## KITTTITAS COUNTY COMMUNITY DEVELOPMENT SERVICES

March 28, 2019

**RE: ATT Teanaway Request for Additional Information (ACU-19-00001)**

**SHEET NUMBER**  
**A-2.0**

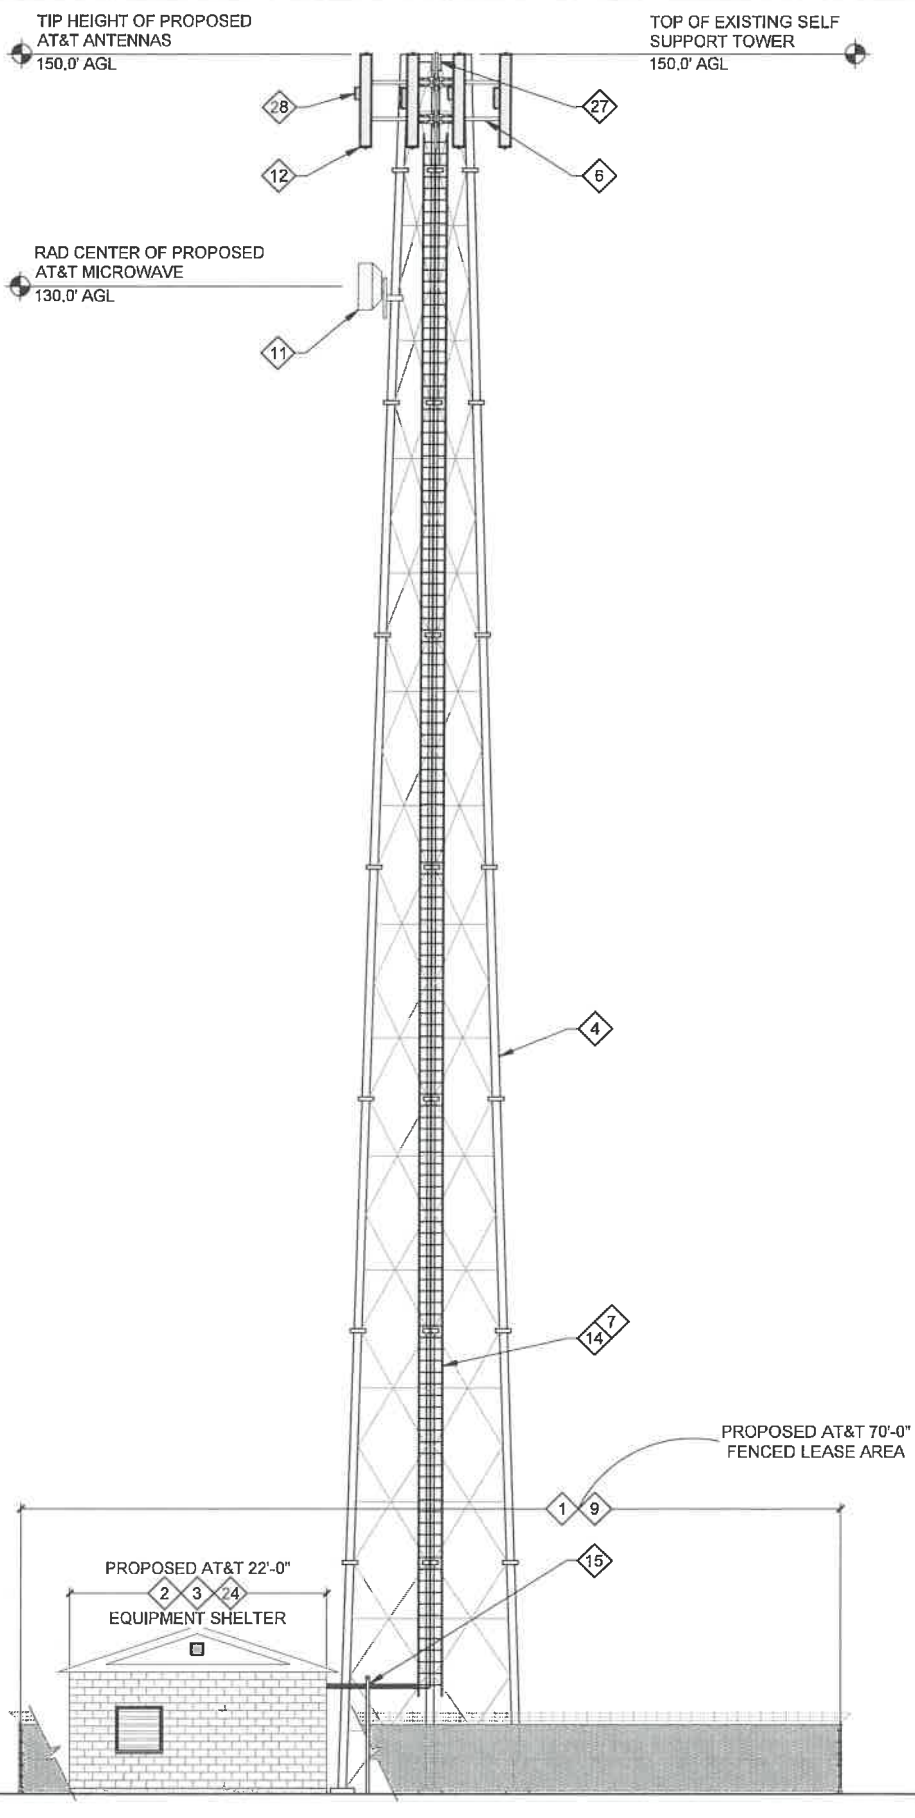
- 1) A revised narrative and SEPA checklist addressing the issues of the emergency generator and its power source, including addressing impervious surface and excavation volume calculations.
- 2) Further revisions to the narrative clarifying the nature of onsite lighting, and explaining the location of the propane tank and solar array outside of the perimeter fence.
- 3) Detailed fire prevention, weed control, and soil management/revegetation plans.
- 4) Details as to the engineering/design of the retaining wall.
- 5) Revisions to the proposal ensuring that the fence will mitigate impacts to wildlife. The fence will be at least 8 feet tall and will use either no barbed wire or a single strand at the top.
- 6) Revisions to the proposal showing a raptor exclusion device.
